Application Ref:	3/2018/0371	 Ribble Valley Borough Council www.ribblevalley.gov.uk
Date Inspected:	06/06/18	
Officer:	RB	
DELEGATED ITEM FILE REPORT:		REFUSAL

Development Description:	Proposed single storey extensions and new garage/annex
Site Address/Location:	Markhor, Eaves Hall Lane, West Bradford, BB7 3JG

PROPOSED GARAGE / ANNEX

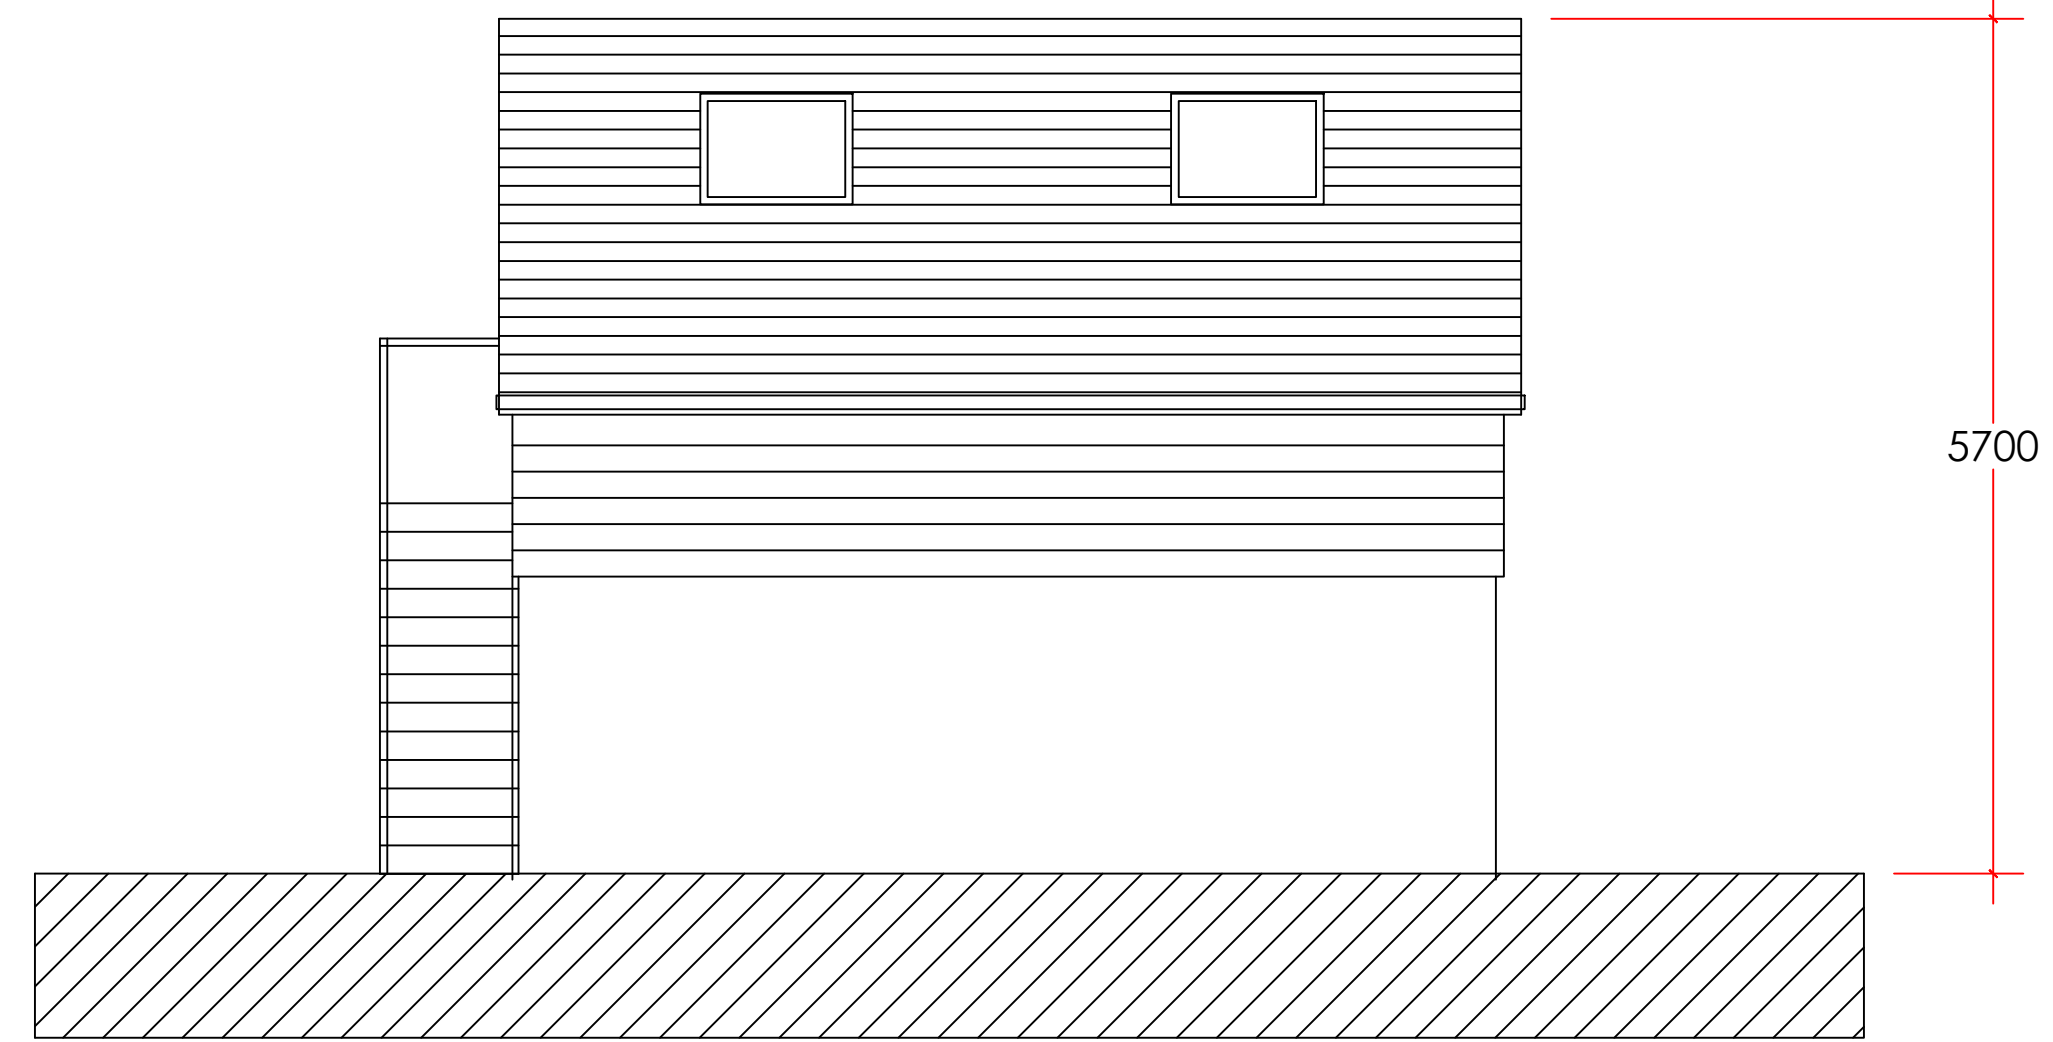
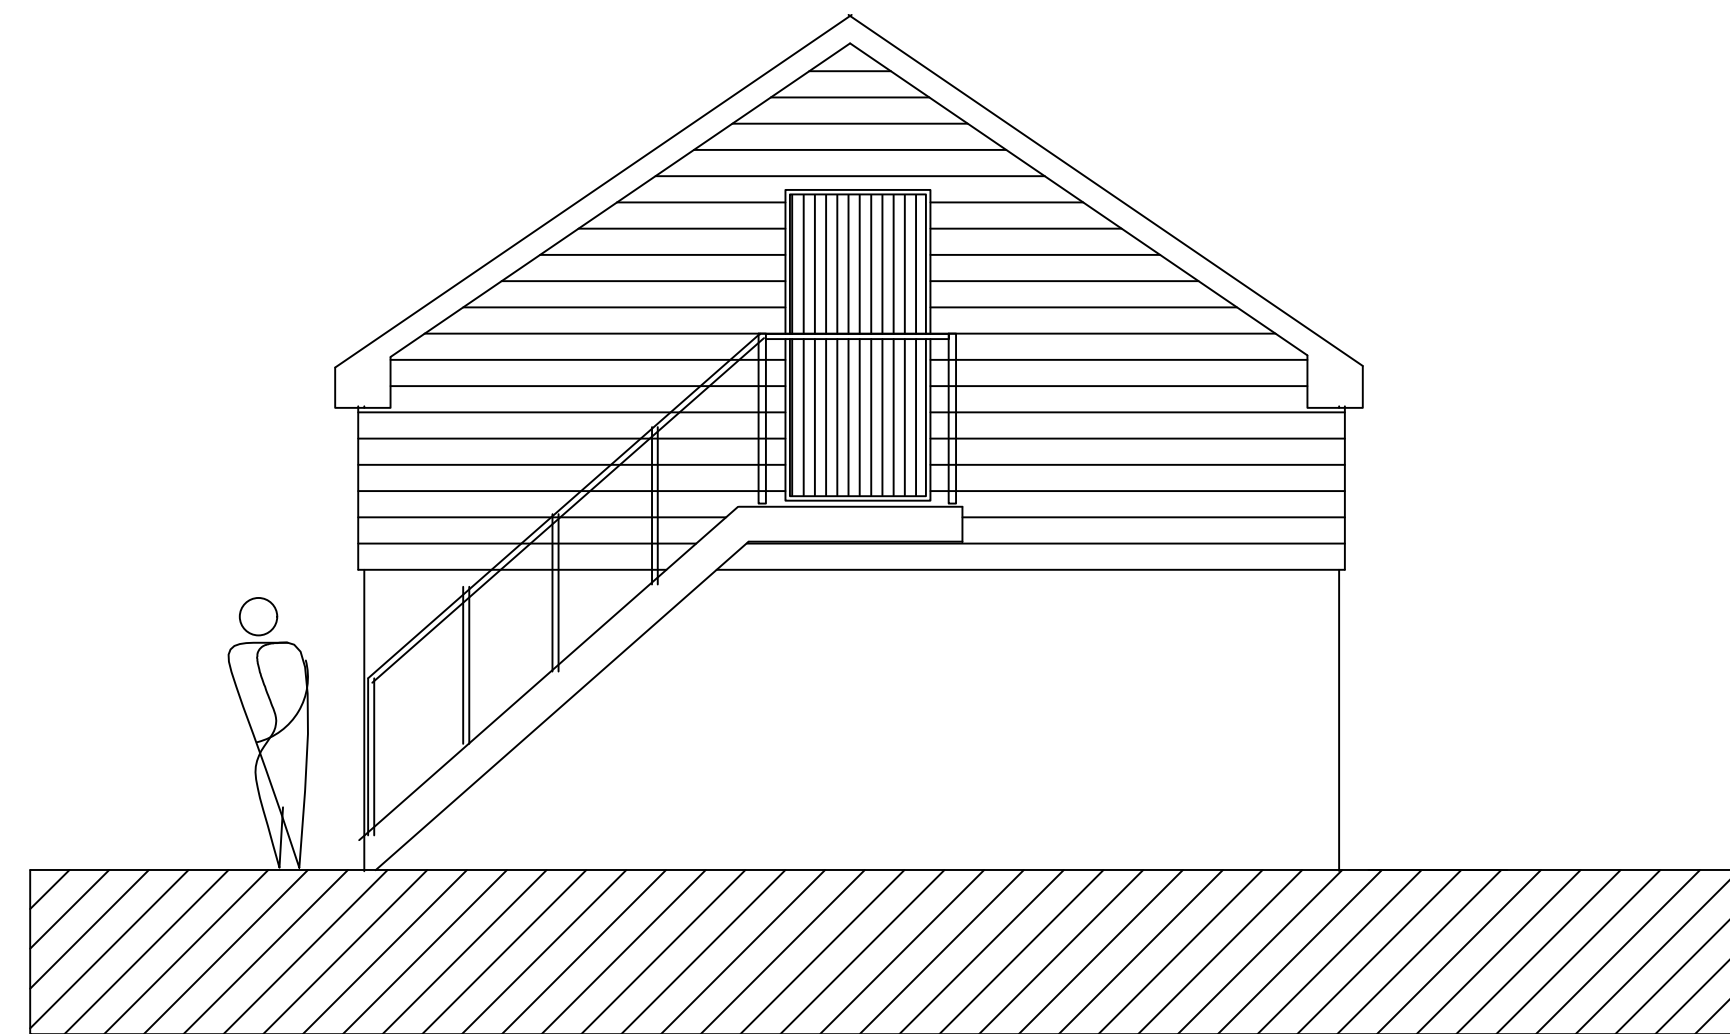
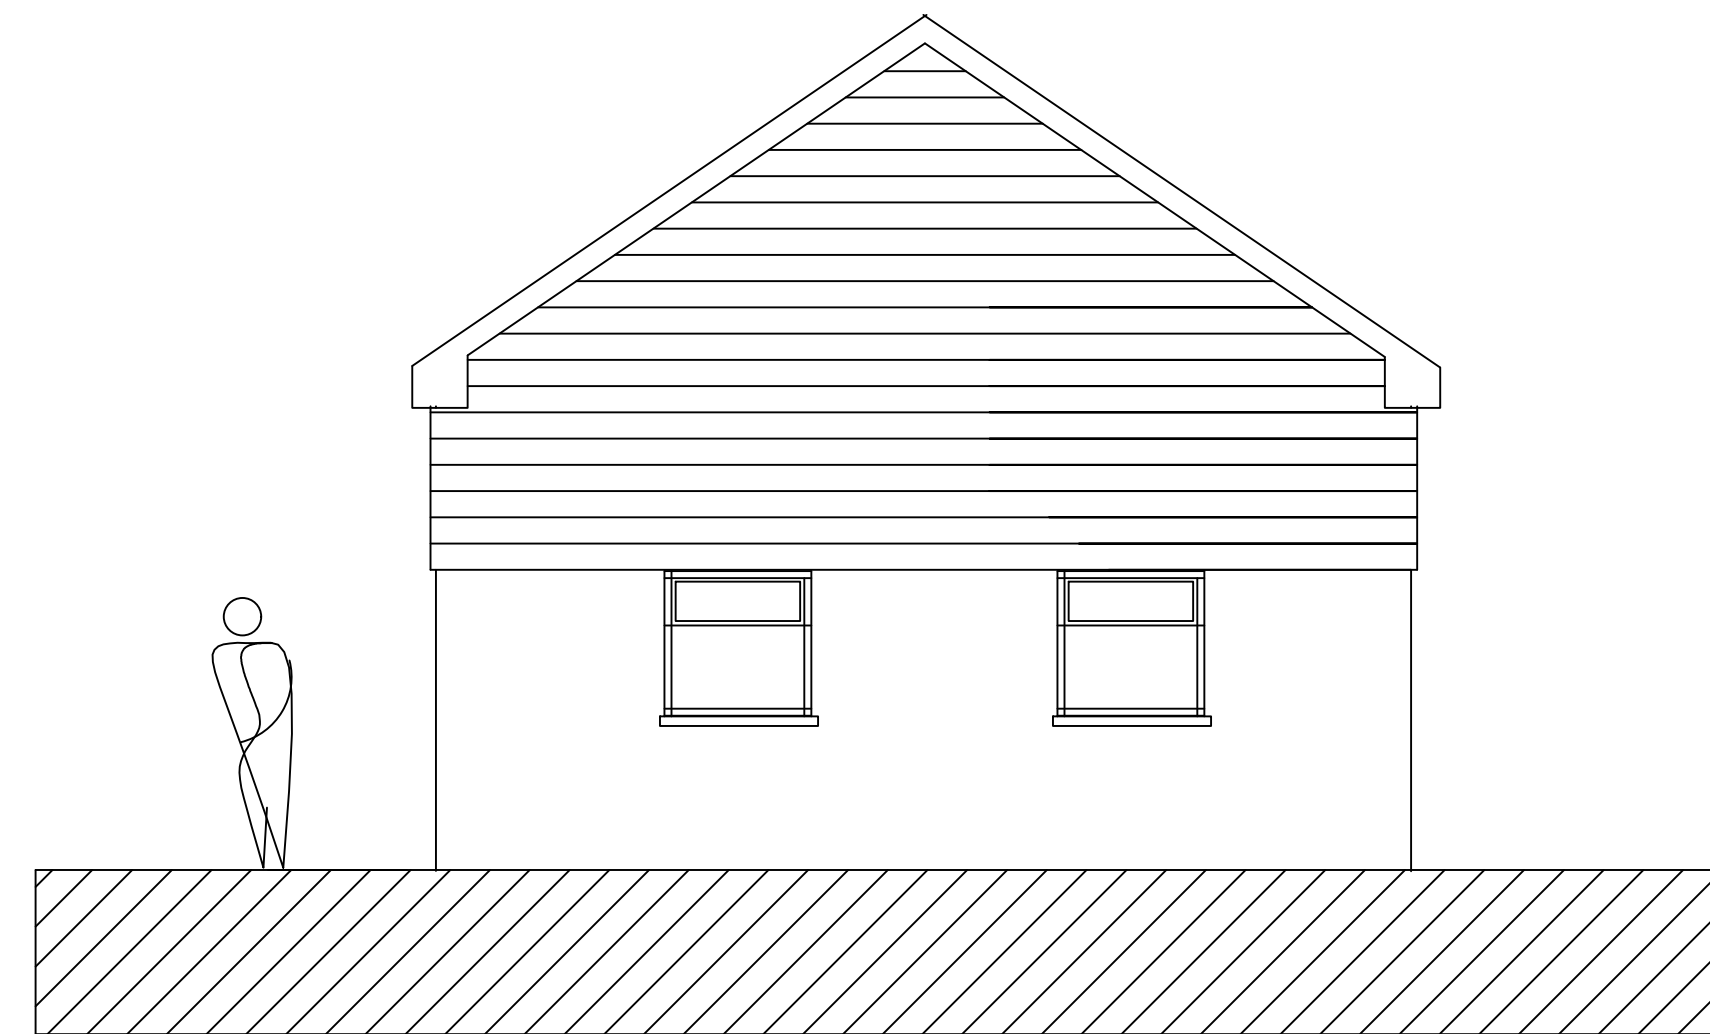
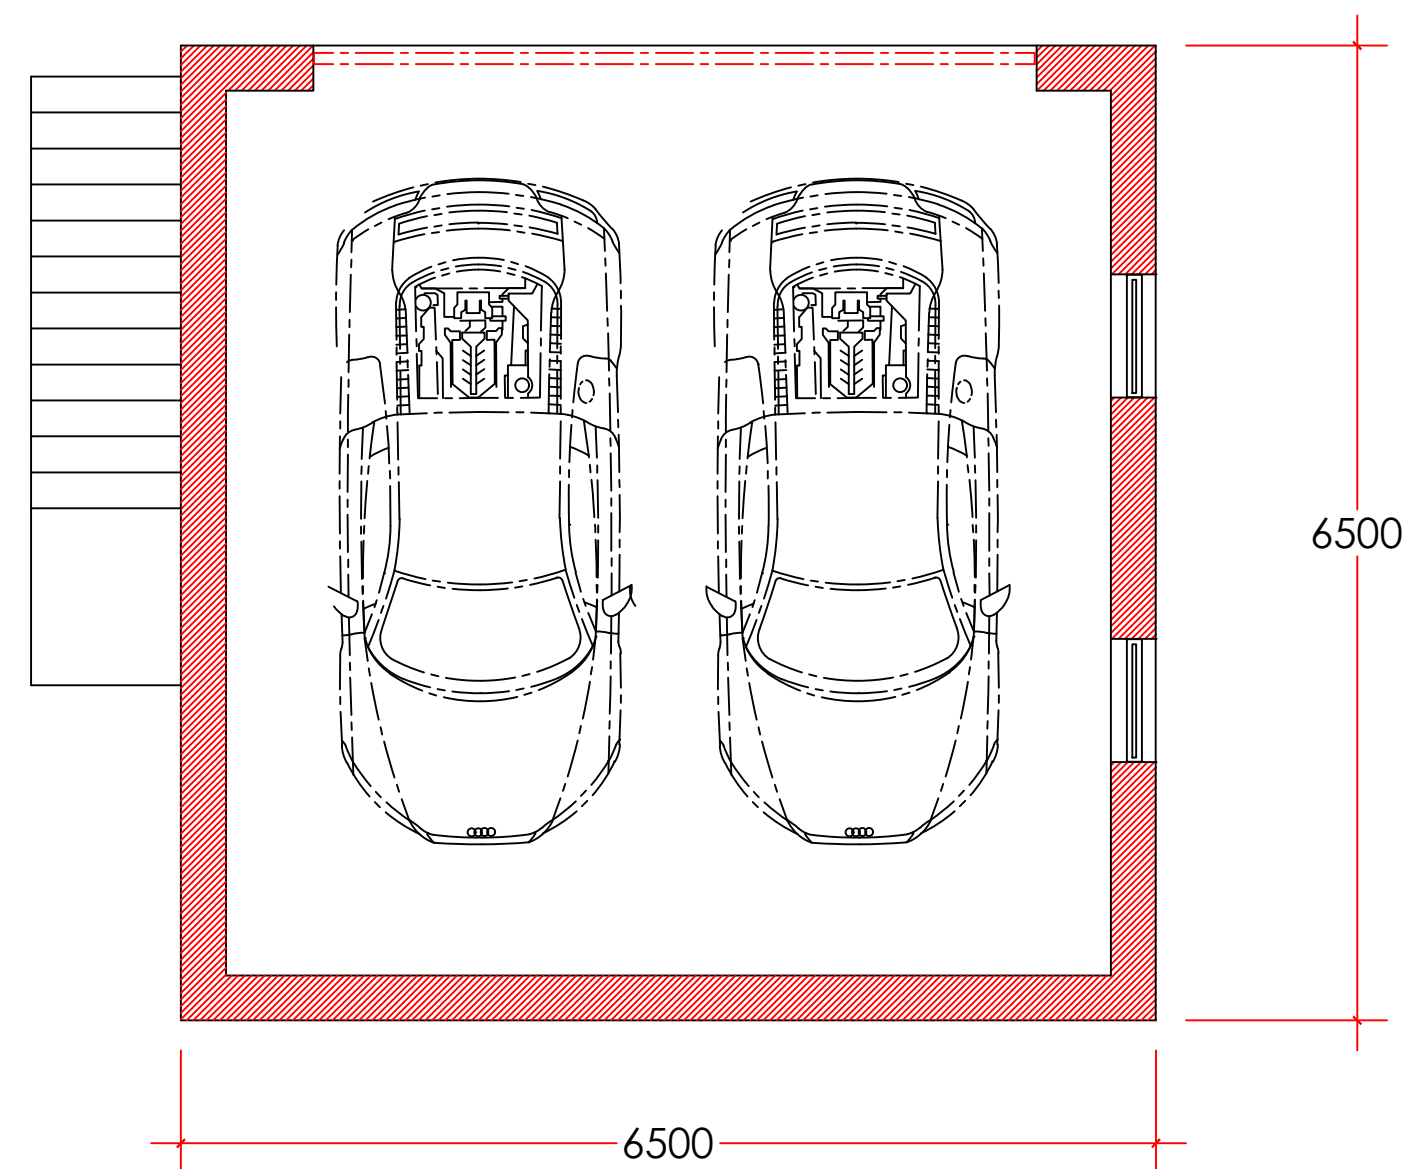
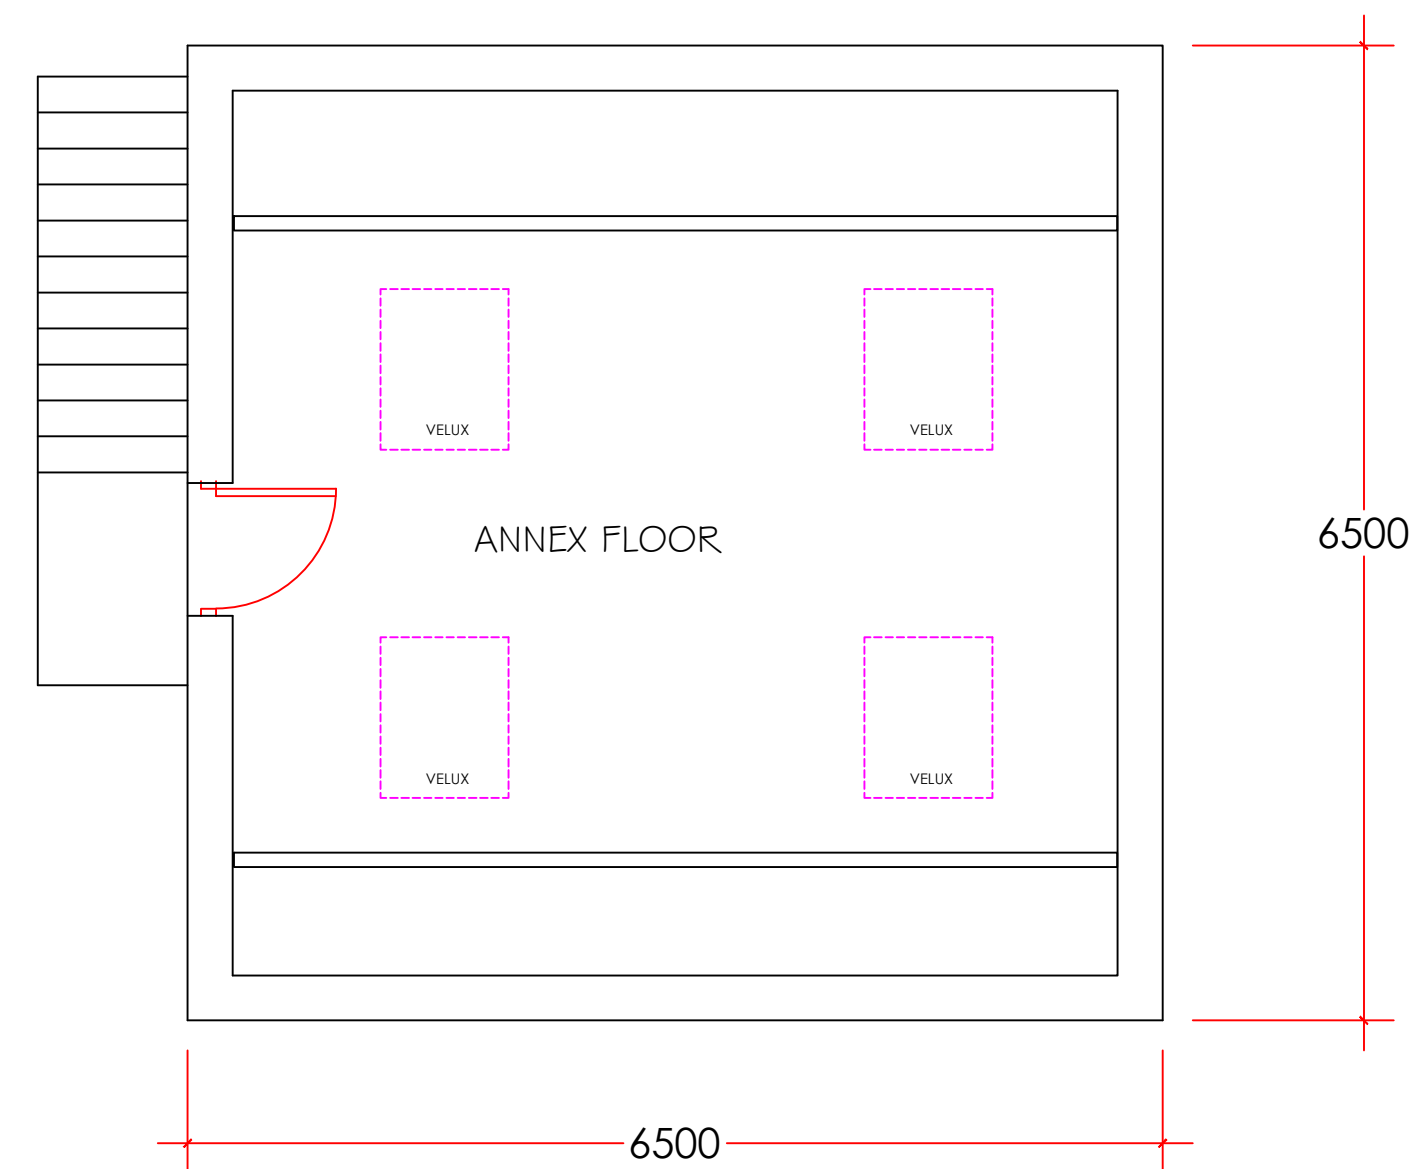
Consent is also sought for the erection of a garage/ annex in the front private garden area of the property falling south of the existing driving area. The garage is approximately 6.5 metres by 6.5 metres with the ridge height at 5.7 metres. The garage is set approximately 2metres from the boundary of the neighbouring property Highfield, projecting approximately 6.5 metres forward of the front of the host dwelling.

It is considered that the visual impact of the breach to the building line is only exacerbated by the scale, size and height of the proposed garage/annex and which will increase its prominence when viewed from the highway and also the Bridleway of Eaves Hall Lane.

It is also considered that due to the proposed annex/garage being forward of the building line and the proposed scale being within close proximity of Eaves Hall that the development would be harmful to the setting of the grade II listed building.

Taking into account the above, it is considered that the proposed garage/annex due to its size, scale and siting that it would significantly dominate and harm the character and appearance of the area. It would therefore be contrary to Policy DMG1 and DMH5 of the Ribble Valley Core Strategy. This policy seeks to ensure, amongst other things, that new development is sympathetic to its context in terms of size, scale and design.

The proposed two storey garage/annex building, by reason of its scale, height, massing, design, appearance and siting forward of the established building line, would result in incongruous feature that over dominates the street scene of Eaves Hall Lane. The building would be prominent and visible from public vantage points in the open countryside (mainly Eaves Hall Lane) and would fail to achieve high quality design that would adequately reflect the local character and vernacular of this location which would also cause harm upon the setting of the adjacent grade II listed building (Eaves Hall). The proposal is thus considered detrimental to the visual amenities of the area which is contrary to Policies DMG1, DME4, DMH5 and Key Statement EN2 of the Ribble Valley Core Strategy, as well as national guidance contained within the National Planning Policy Framework.

A request was made for the siting of the garage to be behind the building line of the host dwelling. The applicant would not agree to this amendment and requested that the application be determined as submitted.
